Your reference: 07_0161 MOD 2
Our reference: EF13/3853, DOC14/212948-01
Contact: Dr. Sandie Jones/Tristan Johnston (02) 62297002

EPA Response - Exhibition of Modification Request for Dongwha Timbers, 1 Sandy Lane Bombala (07_0161 MOD 2)

Outstanding issues with Air Quality Assessment for Dongwha modified plant upgrade

Figure 8 – Predicted 100th percentile 24 hour PM₁₀ level of 10 µg/m³

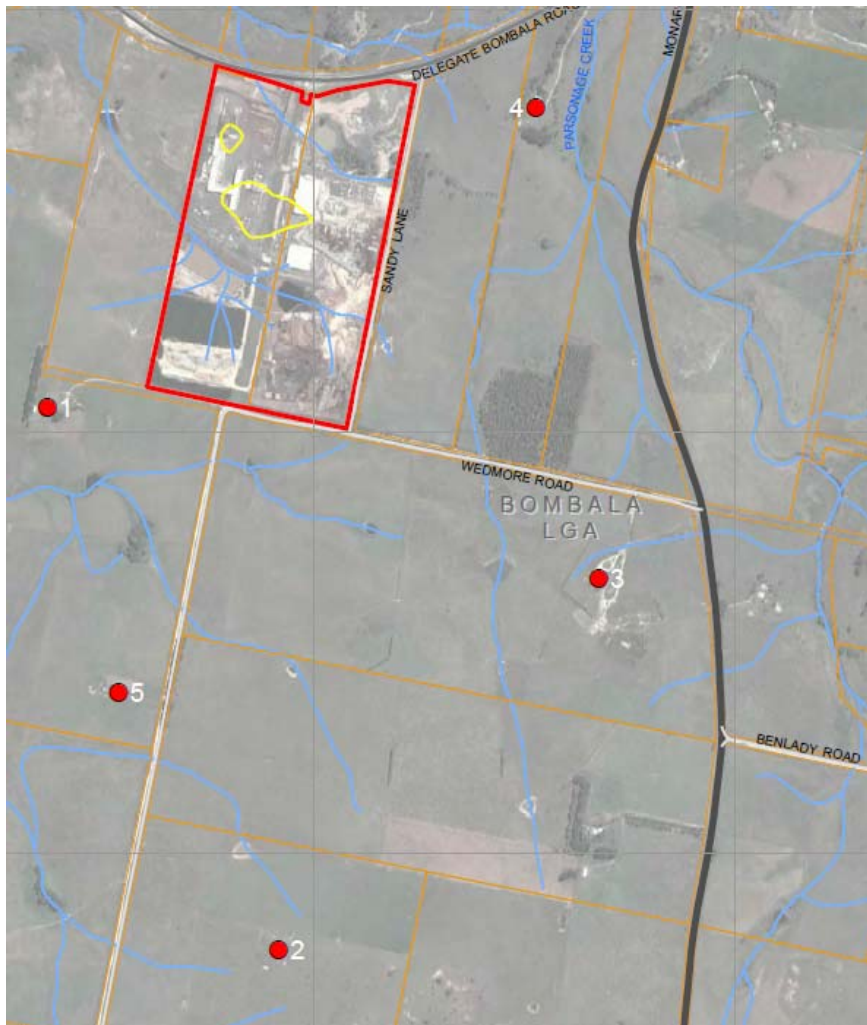
- There is no justification for the choice of 2009 as the modelled year;
- Grid level specification in Table 2 in Appendix C is inconsistent; and
- There are errors in the presentation of model results – concentrations of PM_{2.5} greater than that of PM₁₀.

- Confirmation of the size of the proposed wood-fired boiler.
- Examination of representative meteorological data to determine representative years for modelling impacts and justification of this choice.
- Emissions estimates for the proposed wood-fired boiler consistent with the provisions of Section 9 of the Approved Methods. Emissions estimation needs to be based on the performance of the boiler to be installed for the fuel to be used using manufacturer's specifications and any available measurements of operational emissions.
- Modelling of the impact of the proposed wood-fired boiler using emissions estimates representing operation as noted above, and representative meteorology.
- Careful presentation of model parameters and results.

Figure 9 - Predicted 100th percentile 24 hour PM_{2.5} level of 10 µg/m³

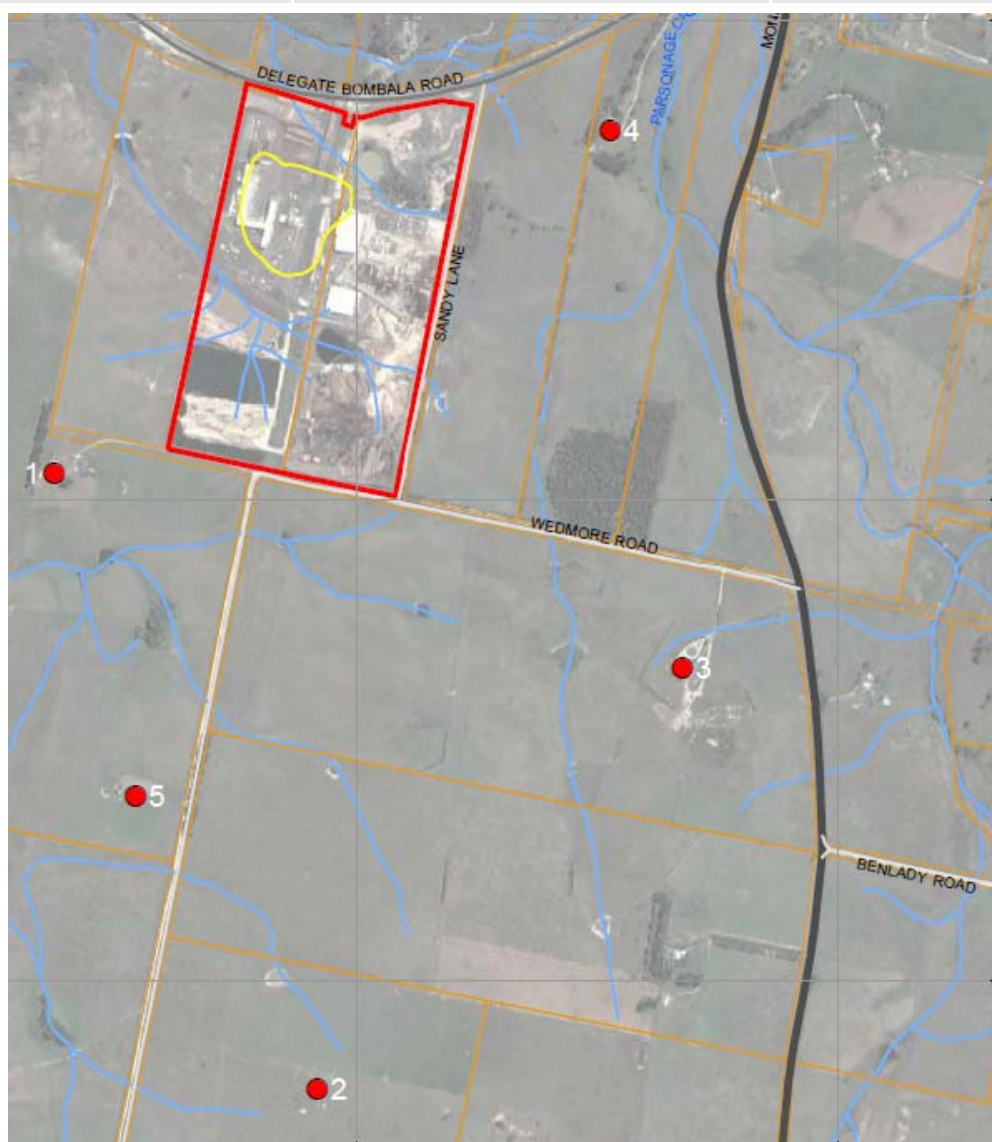
The AQA adopts a criterion for 24-hour PM_{2.5} of 50 µg/m³ with no explanation. New South Wales has not established a 24-hour guideline concentration for PM_{2.5}. Values are available from international jurisdictions, and the National Environment Protection (ambient air quality) Measure sets 25 µg/m³ as an advisory guideline for 24-hour PM_{2.5}. Any criterion chosen needs to be less than that for PM₁₀.

Figure 10 - Predicted 100th percentile 1 hour CO level of 0.1 mg/m³

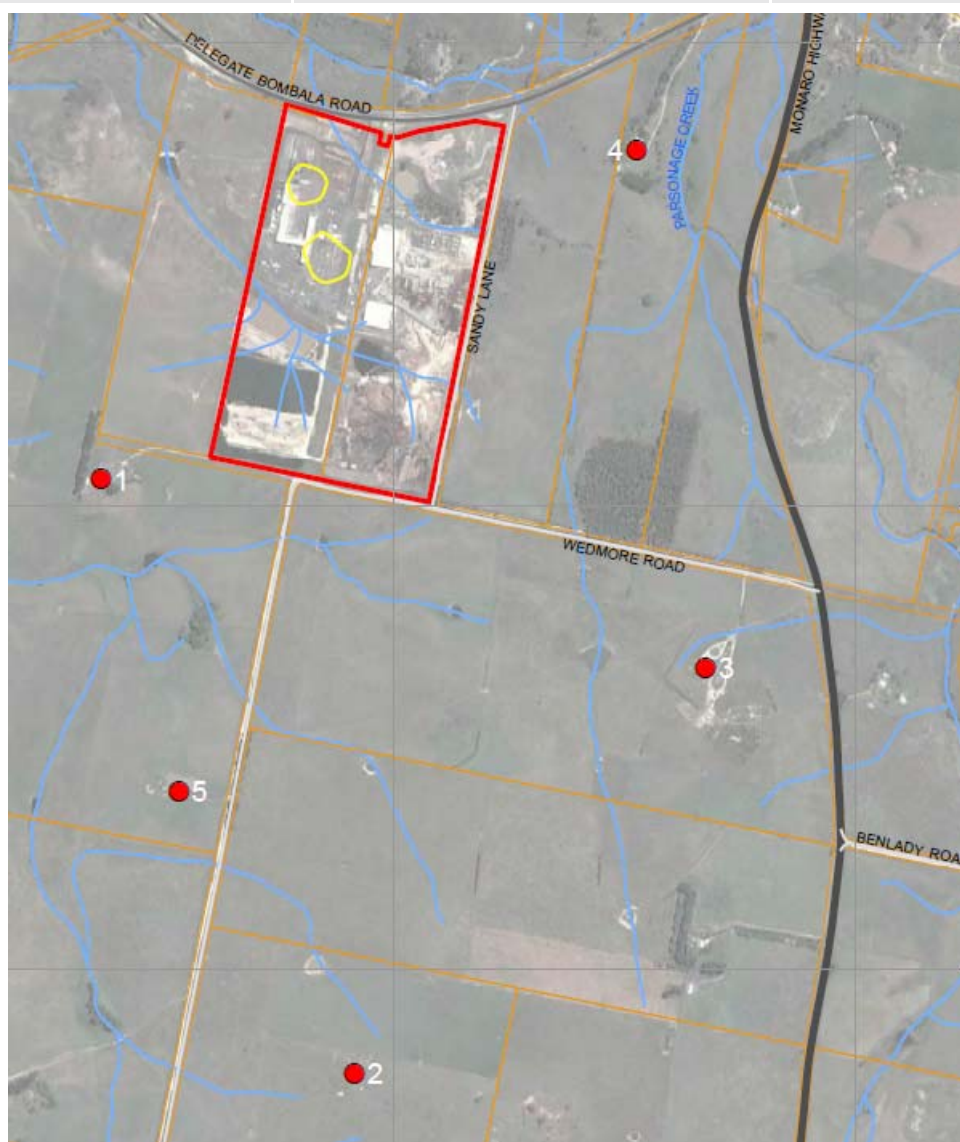
Of most significance is the emissions used in the modelling. The modelling was conducted assuming emissions at the class 6 limits, even though Appendix A of the Air Quality Assessment (AQA) lists a greater emission value for carbon monoxide (5.56 g/s where class 6 would be 2.697 g/s). This is not an acceptable approach for determining emissions for modelling.
